From: Susan Leeson
Sent: 07 September 2011 10:25
To: 'Wayne Gander'
Subject: RE: Glenlogie, Clarence Road, Bognor Regis
Wayne

GLENLOGIE & WEE GLENLOGIE, CLARENCE ROAD, BOGNOR REGIS

PROPOSAL : Conversion from house of multiple occupancy into 8 self contained apartments plus 2 new dwelling houses built in the rear gardens (Arun DC application ref : BR/148/11)

TRAFFIC PARKING STUDY

GLENLOGIE, CLARENCE ROAD, BOGNOR REGIS
Proposals 03 B
Oct/Nov 2010

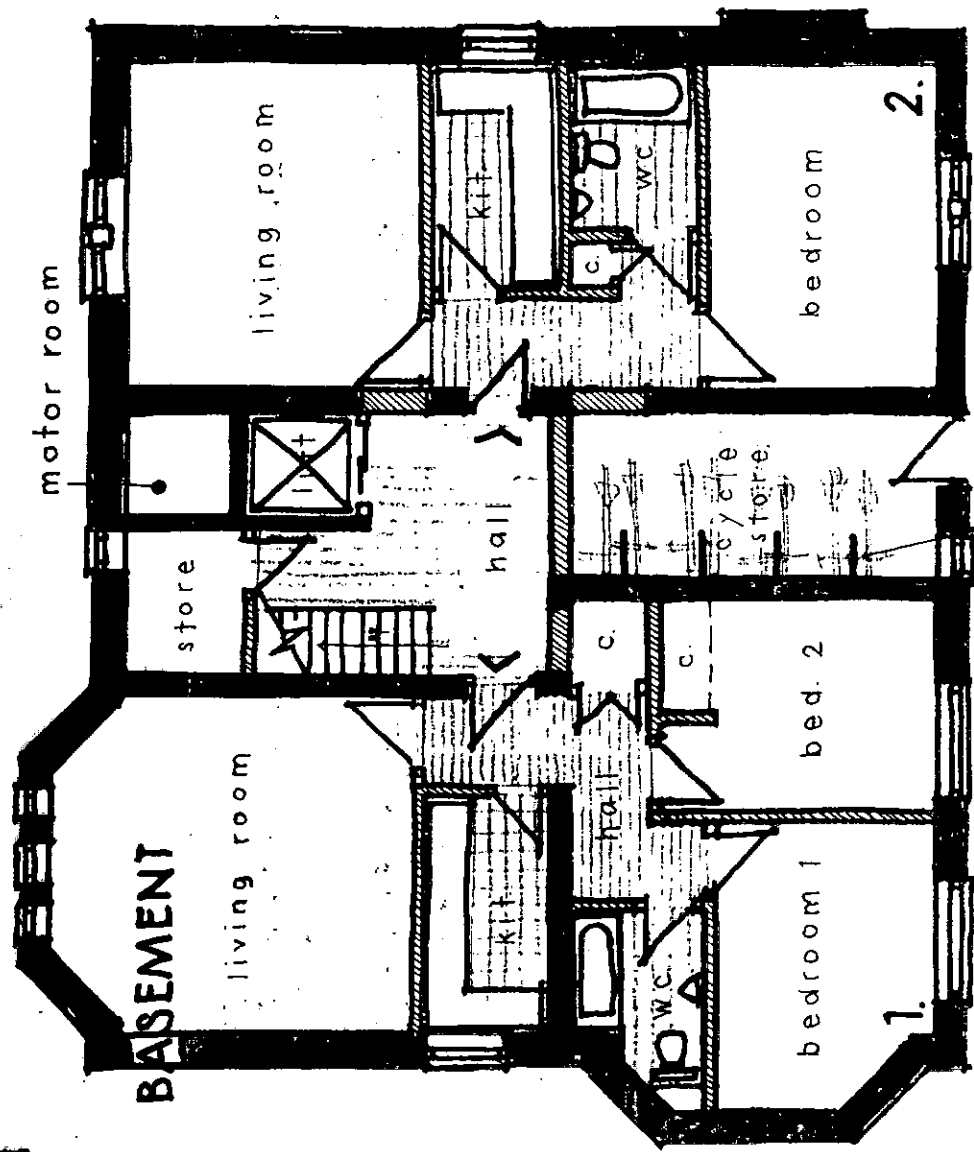
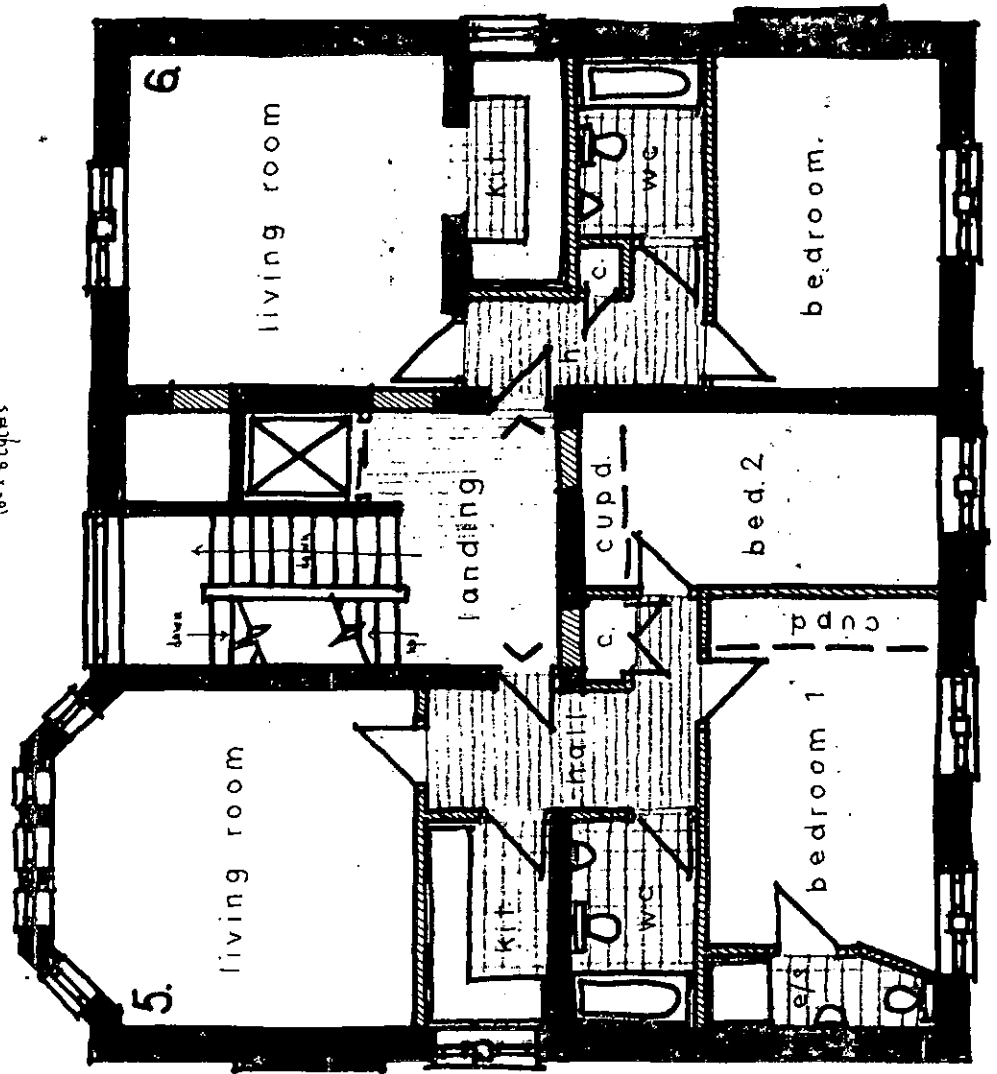
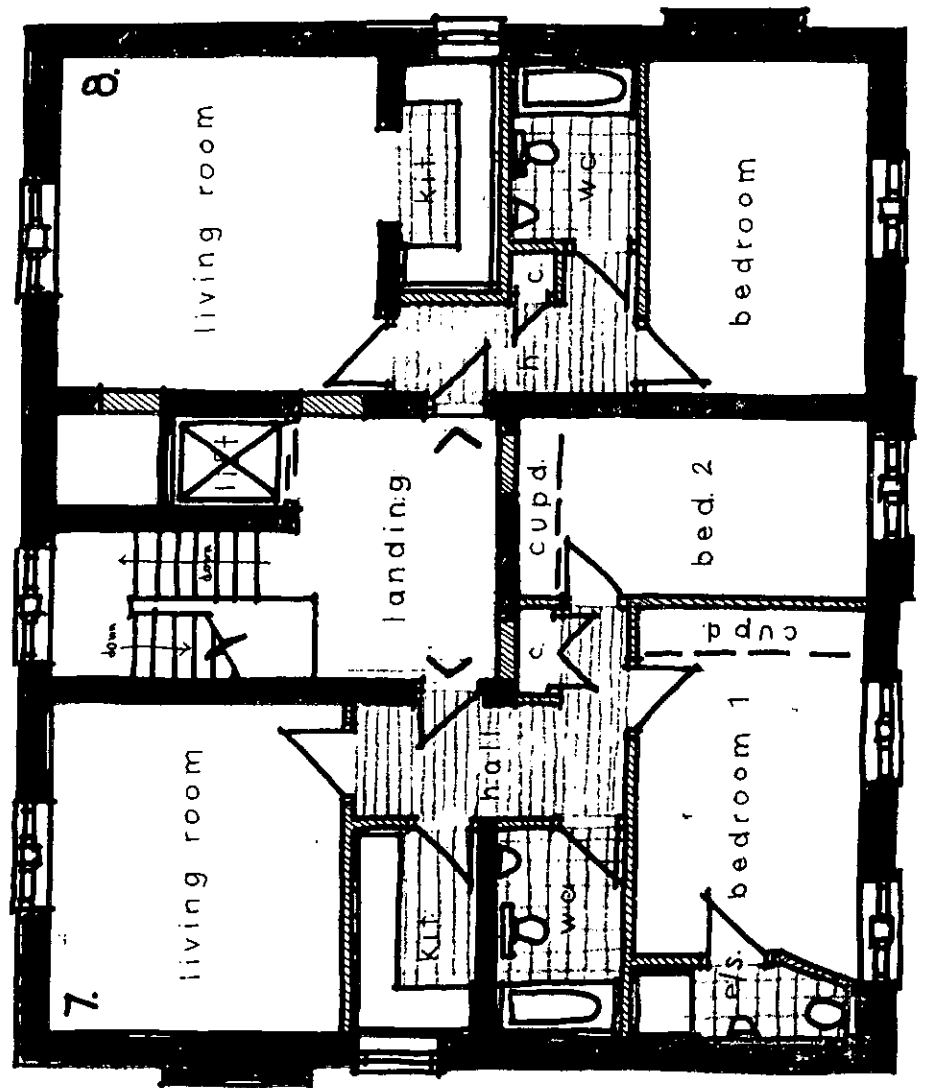
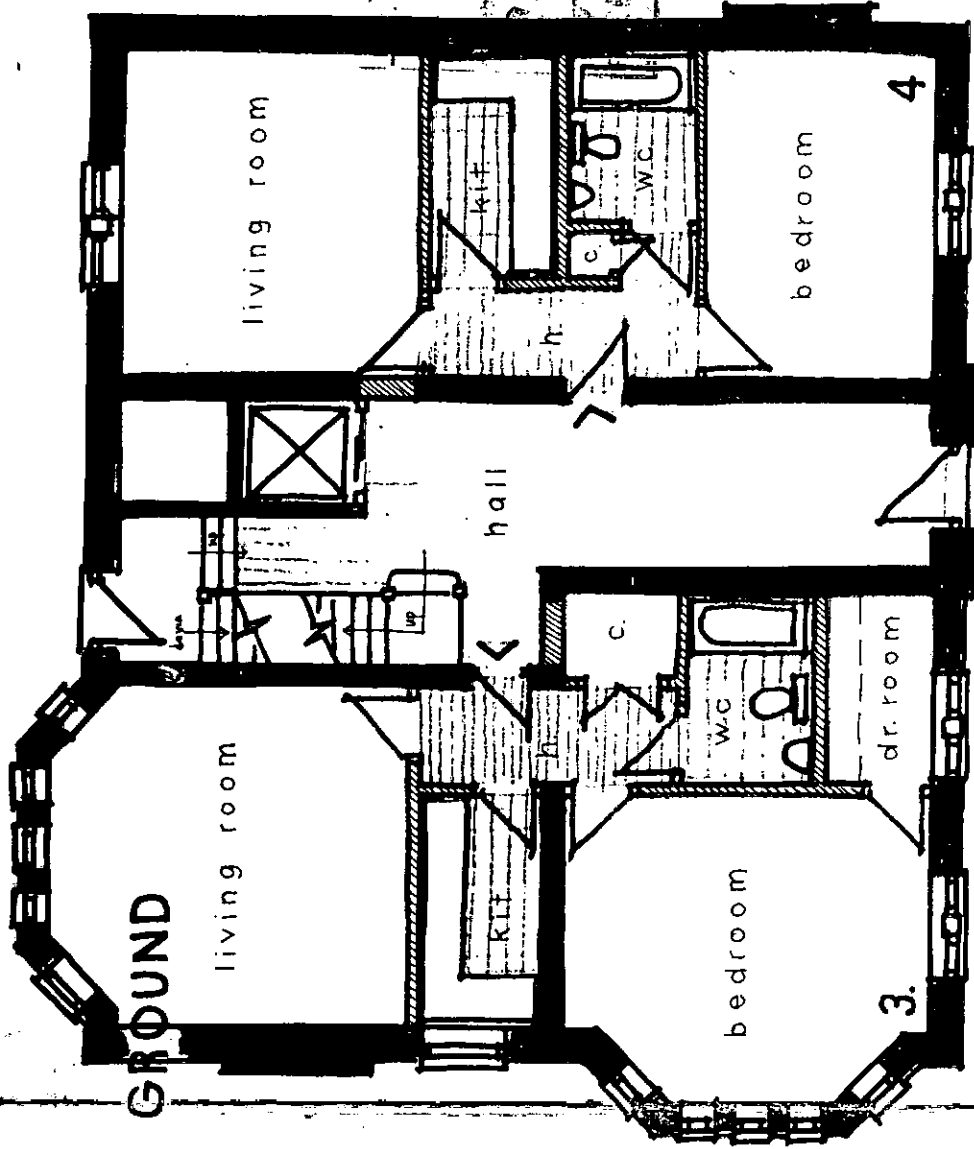
Thank you. I have had a brief chat to Iain and he has confirmed that he will raise no objections to the car parking subject to the provision of 1 covered cycle space per unit in Glenloggie. Please can you therefore revise your plan to show this.
